Rezoning Transportation Analysis

Petition Number: 2020-027

Revision Log:

Date	Description
02-18-2020	First Review
05-11-2020	Second Review

A TYPICAL RESIDENTIAL STREET SECTION (MX ONLY)

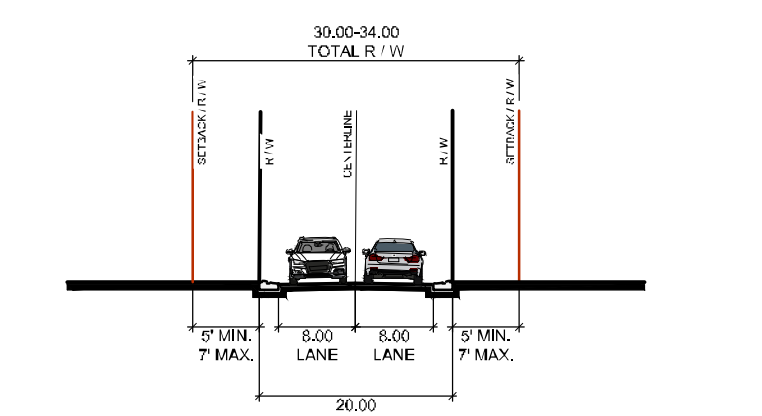
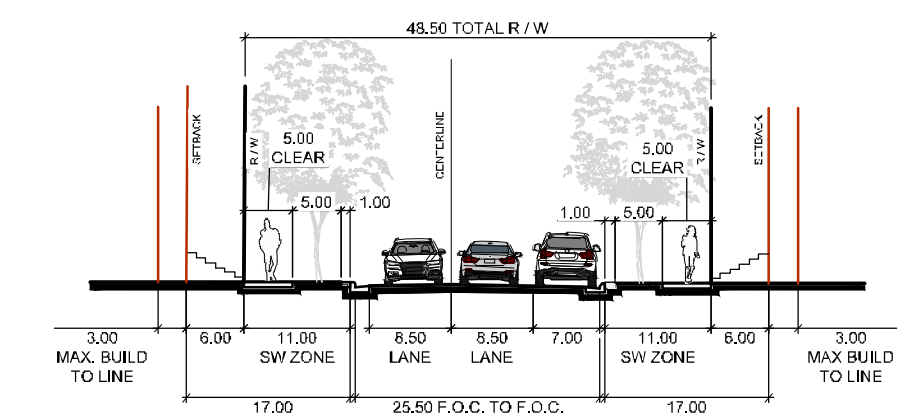
3. The petitioner should revise the site plan and conditional note(s) for street typical "A" and "B" to provide 10.5-foot travel lanes to meet the minimum Subdivision ordinance Urban Street Design Typical.

4. The petitioner should revise the site plan and conditional note(s) for street typical "A" and "B" to provide an 8-foot wide minimum planting street and 6-foot minimum sidewalk width to meet the minimum ordinance requirements.
